**DEPARTMENT OF THE ARMY
WILMINGTON DISTRICT, CORPS OF ENGINEERS**

ORM ID SAW-2007-00157-164

Reference the Department of the Army permit issued to you on May 21, 2009, for the Rocky Mount Northern Connector, TIP R-2823, starting from SR 1604 (Hunter Hill Road) and ending at US 301, in Nash County and your written request of June 11, 2009, for permit modification. The permit modification requests are as follows:

Subject: MODIFICATION to 401 Water Quality Certification Pursuant to Section 401 of the Federal Clean Water Act and TAR-PAMLICO BUFFER RULES with ADDITIONAL CONDITIONS for Proposed Rocky Mount Northern Connector in Nash County, State Project No. 34509.1.1, TIP No. R-2823. DWQ Project No. 20081859 ver. 2.

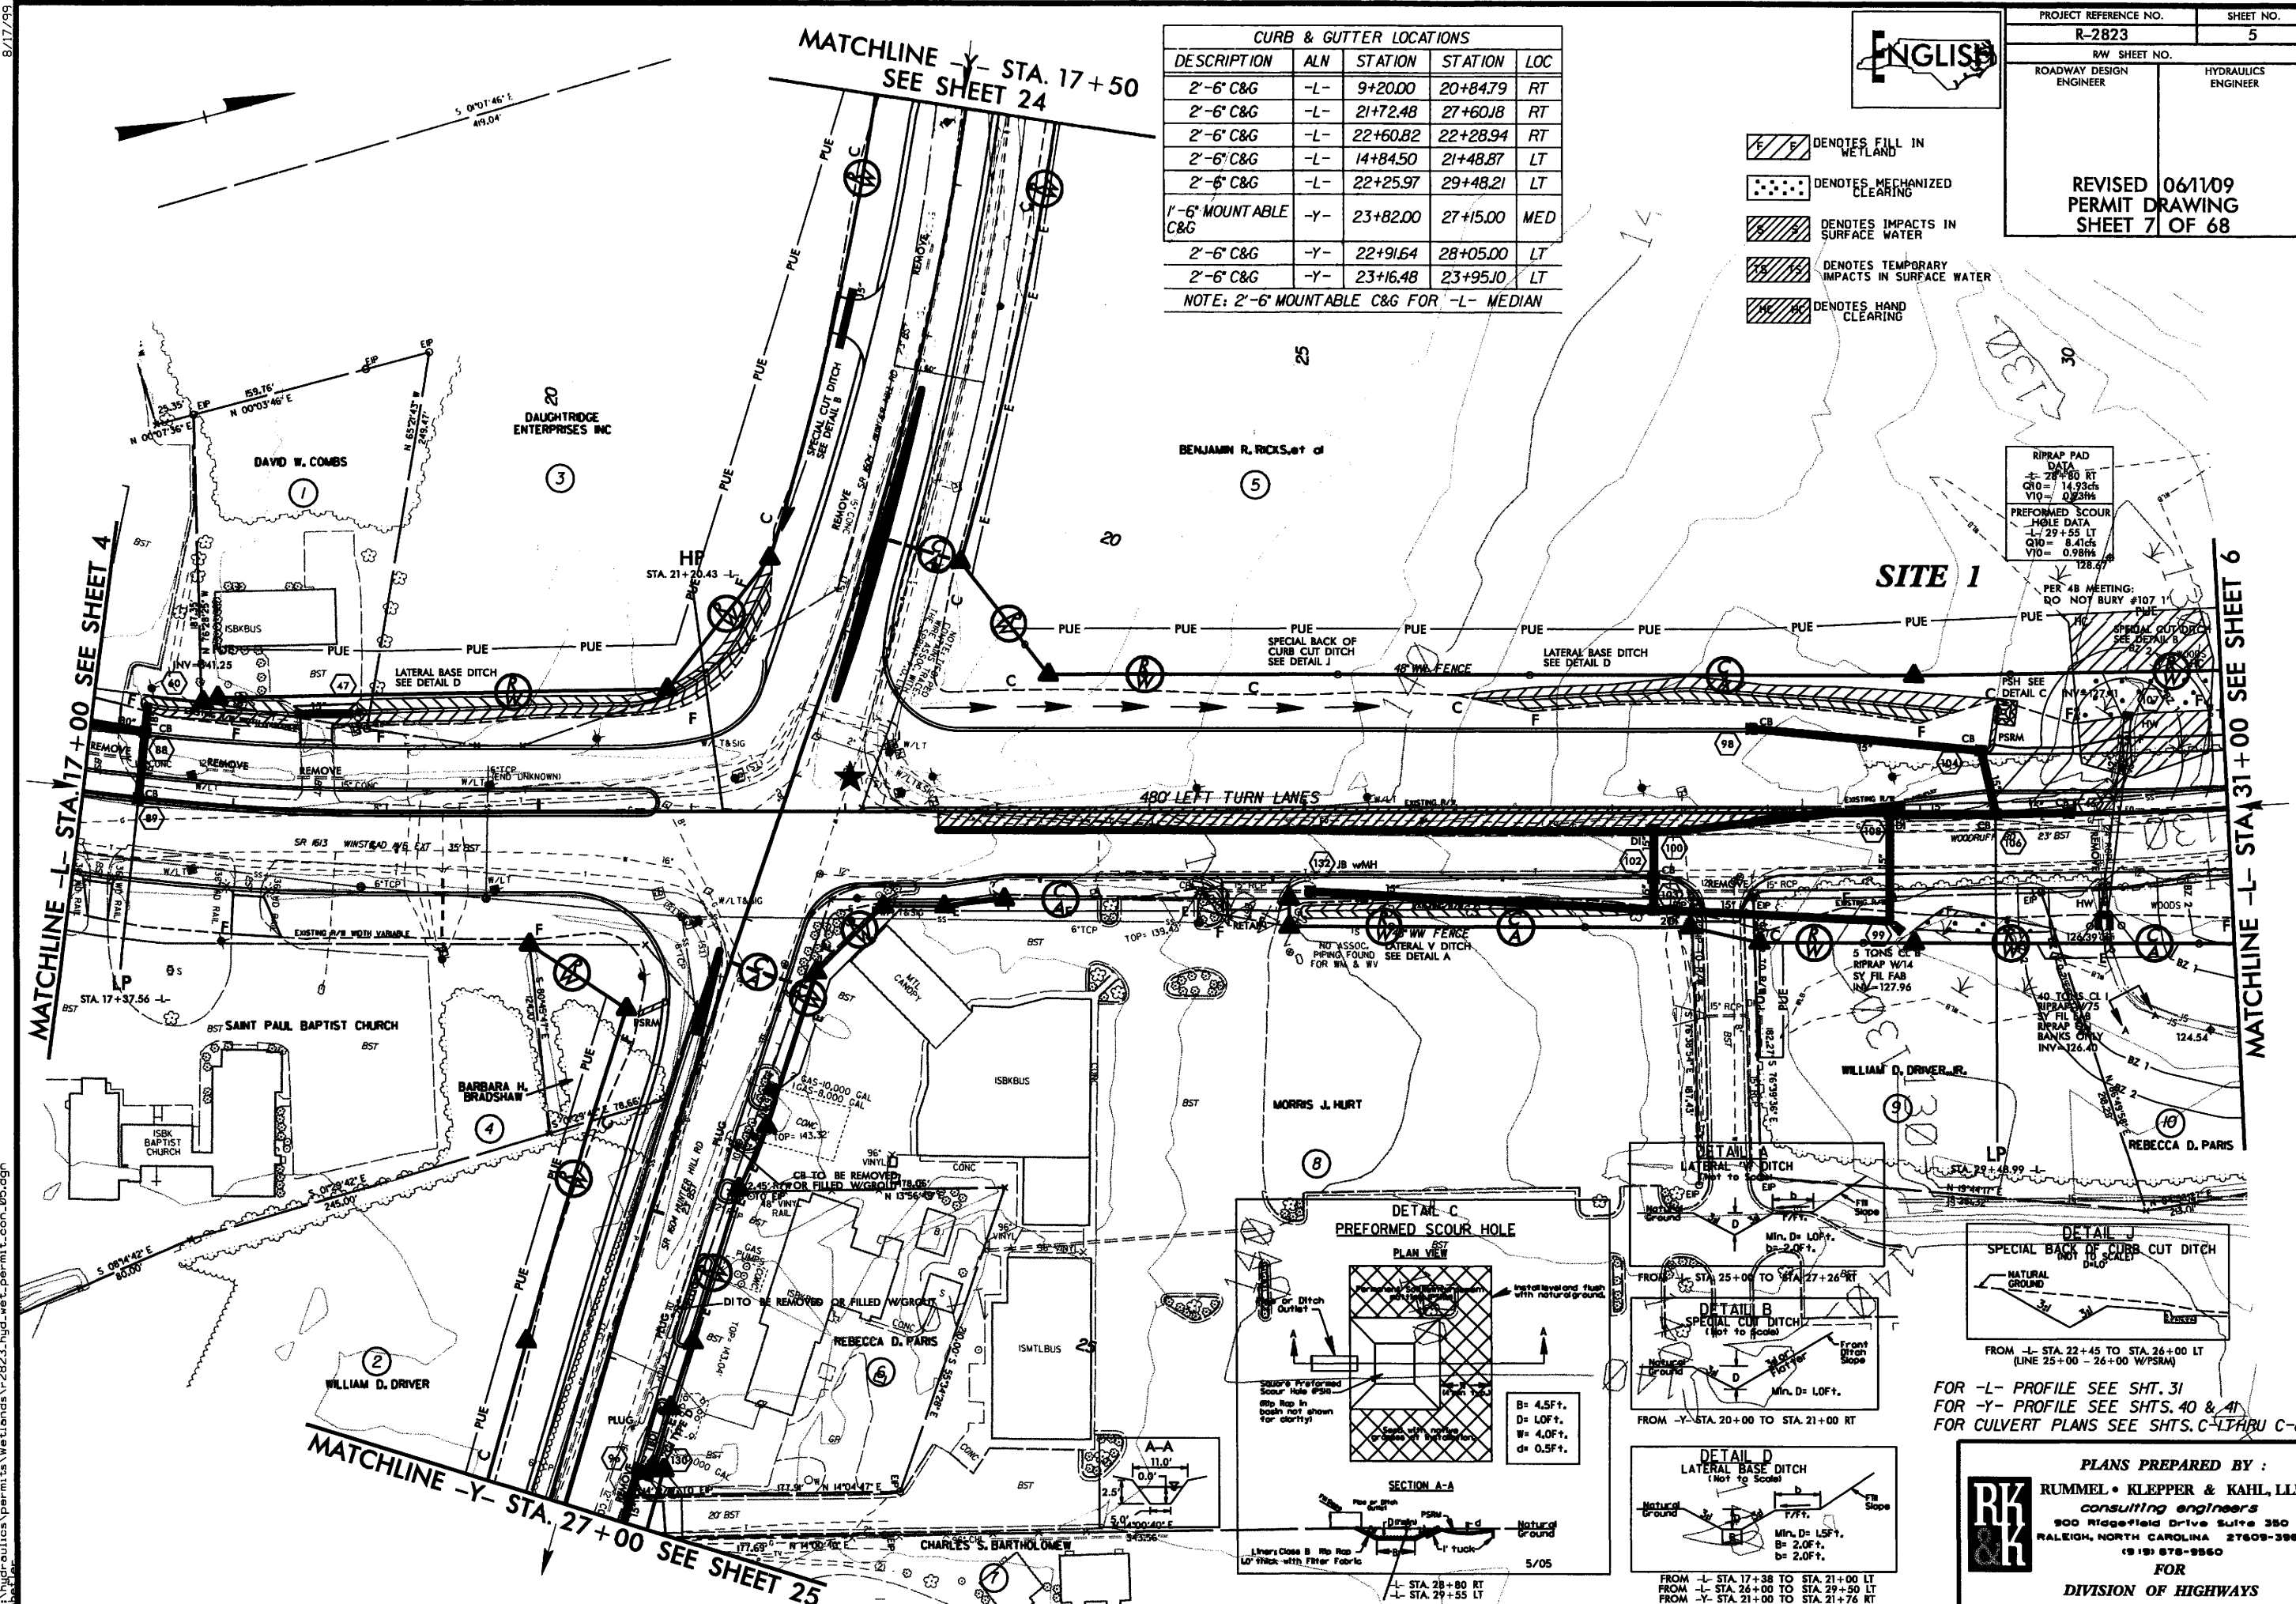
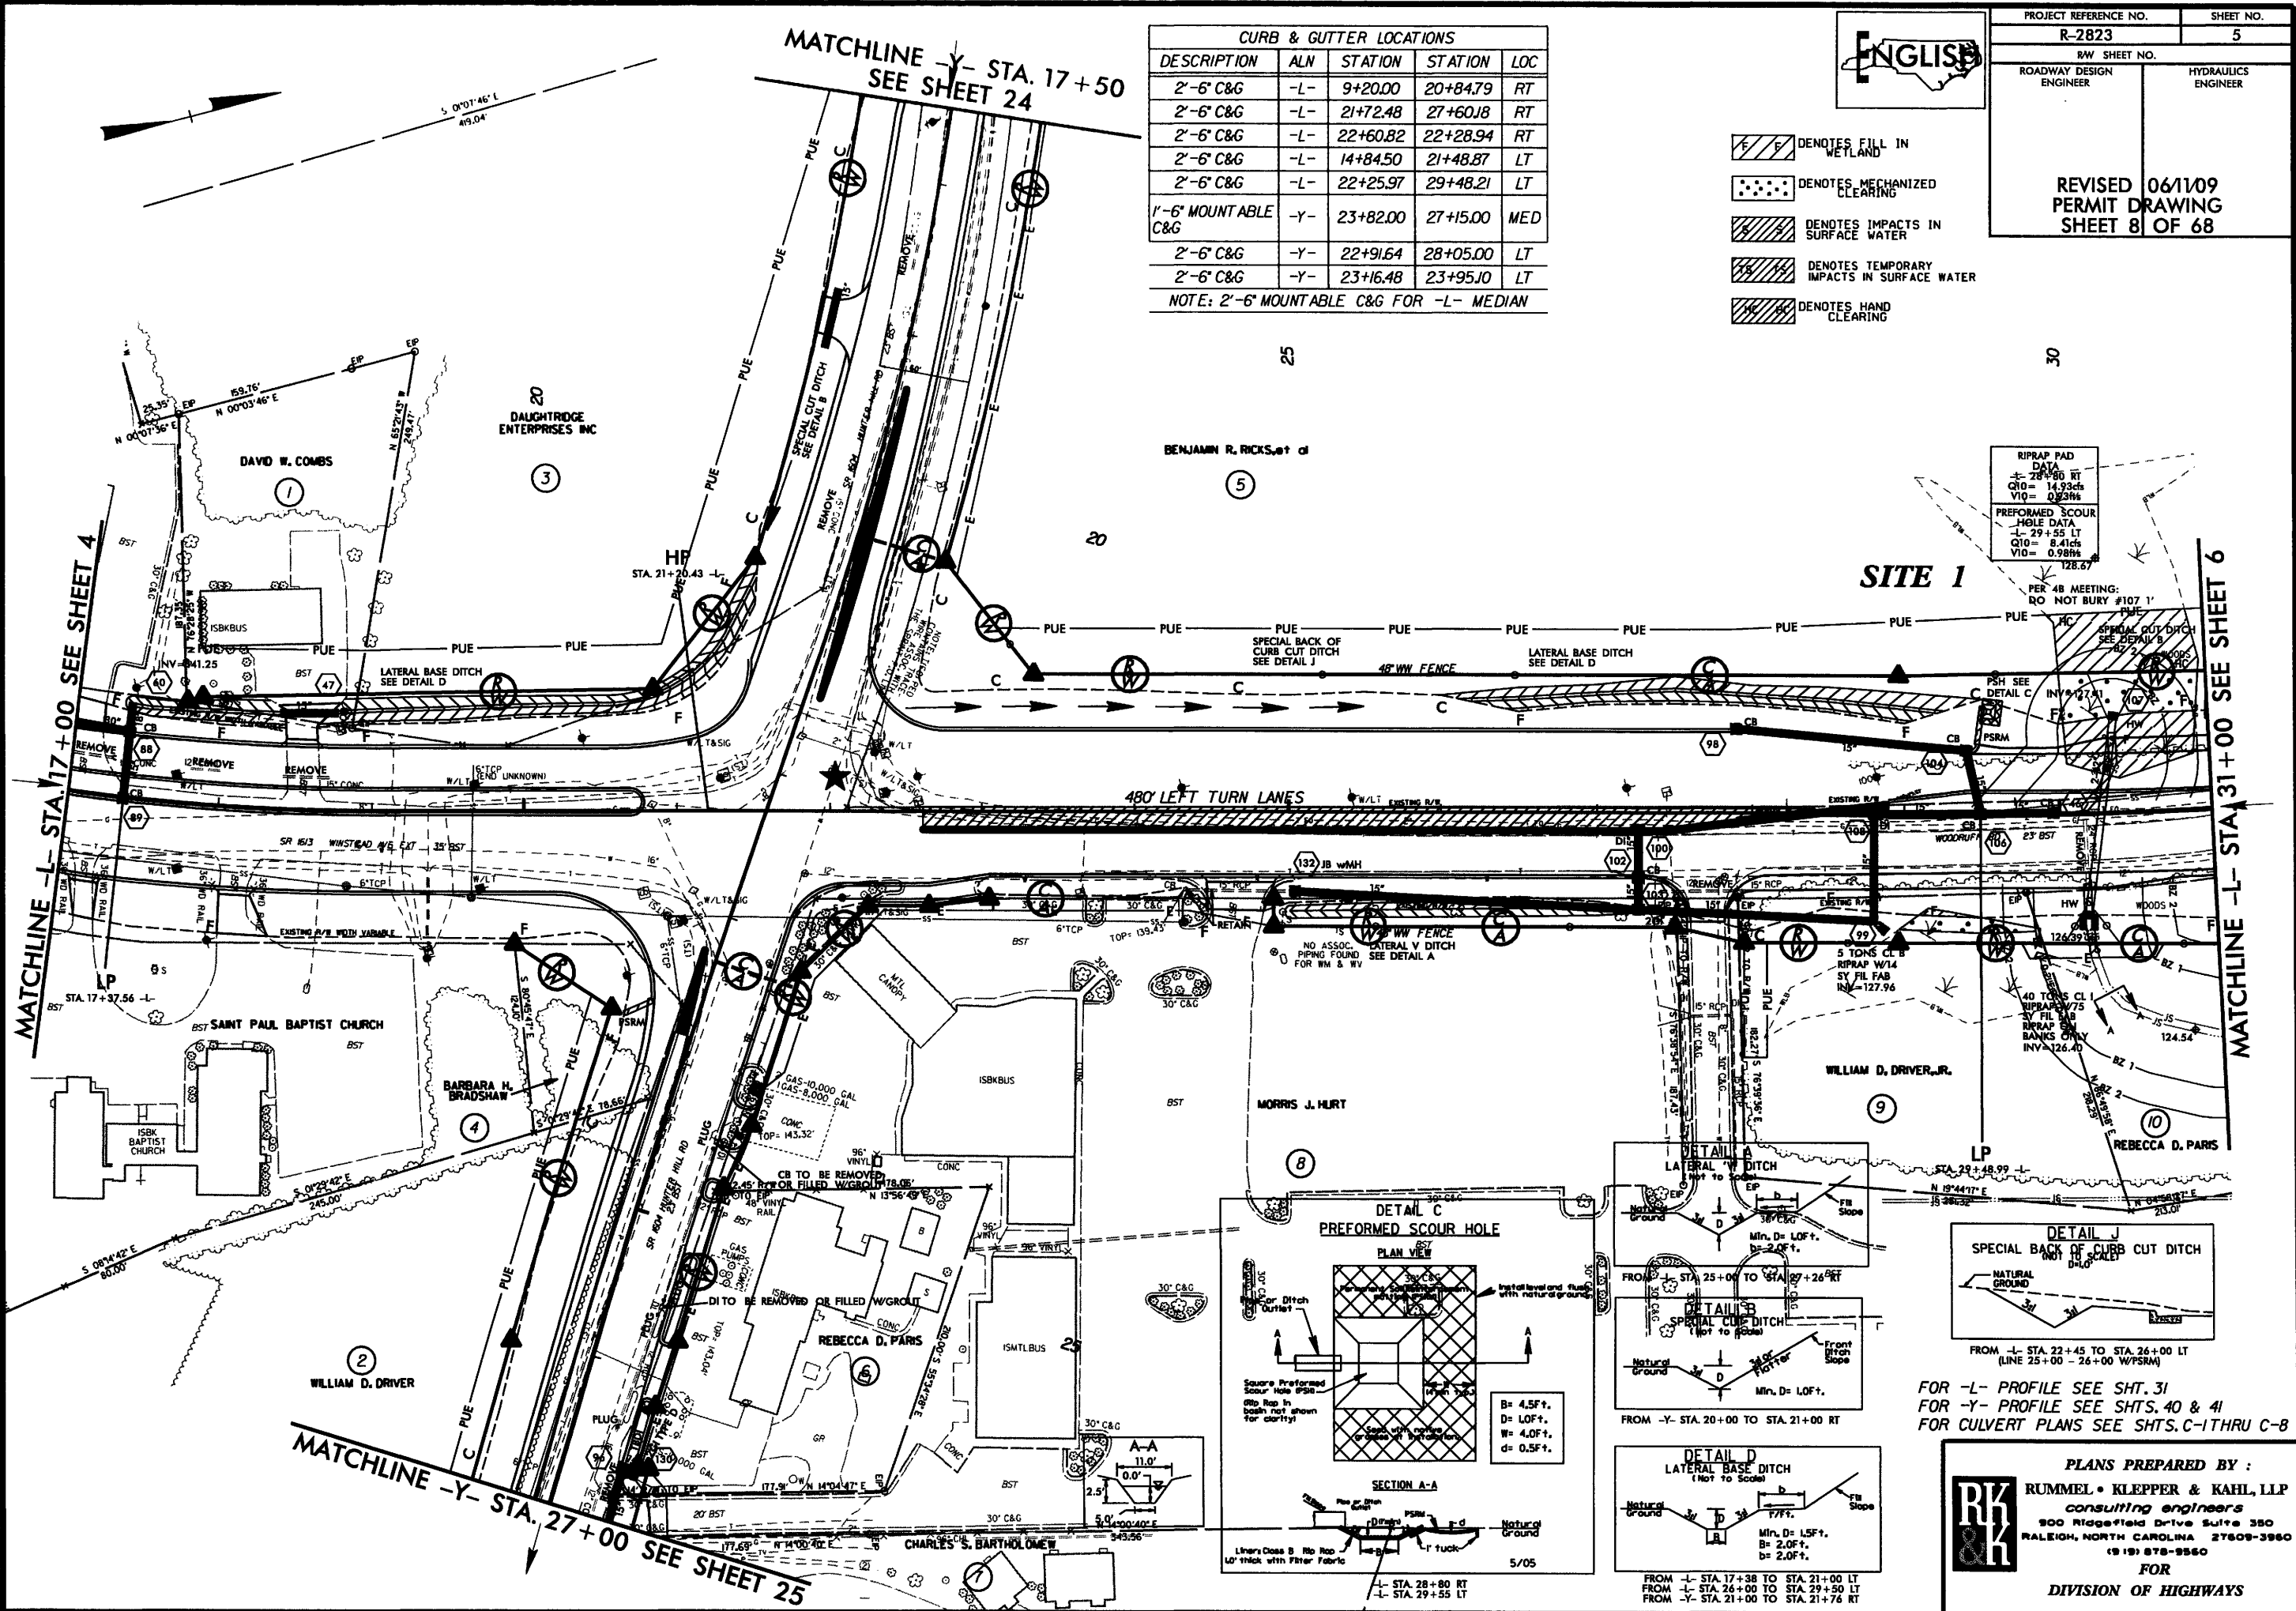
Site 1	Sheets 7 & 8	Additional wetland impacts: 0.01 acre of fill; 0.02 acre of mechanized clearing; 0.08 acre of hand clearing
Site 3	Sheets 11 & 12	Additional wetland impacts: 0.02 acre of fill; 0.04 acre of hand clearing
Site 5	Sheets 14 & 15	Additional wetland impacts: 0.11 acre of hand clearing
Site 13	Sheets 43 & 44	Additional wetland impacts: 0.05 acre of fill Reduced wetland impacts: 0.01 acre of mechanized clearing Additional stream impacts: 13 linear feet
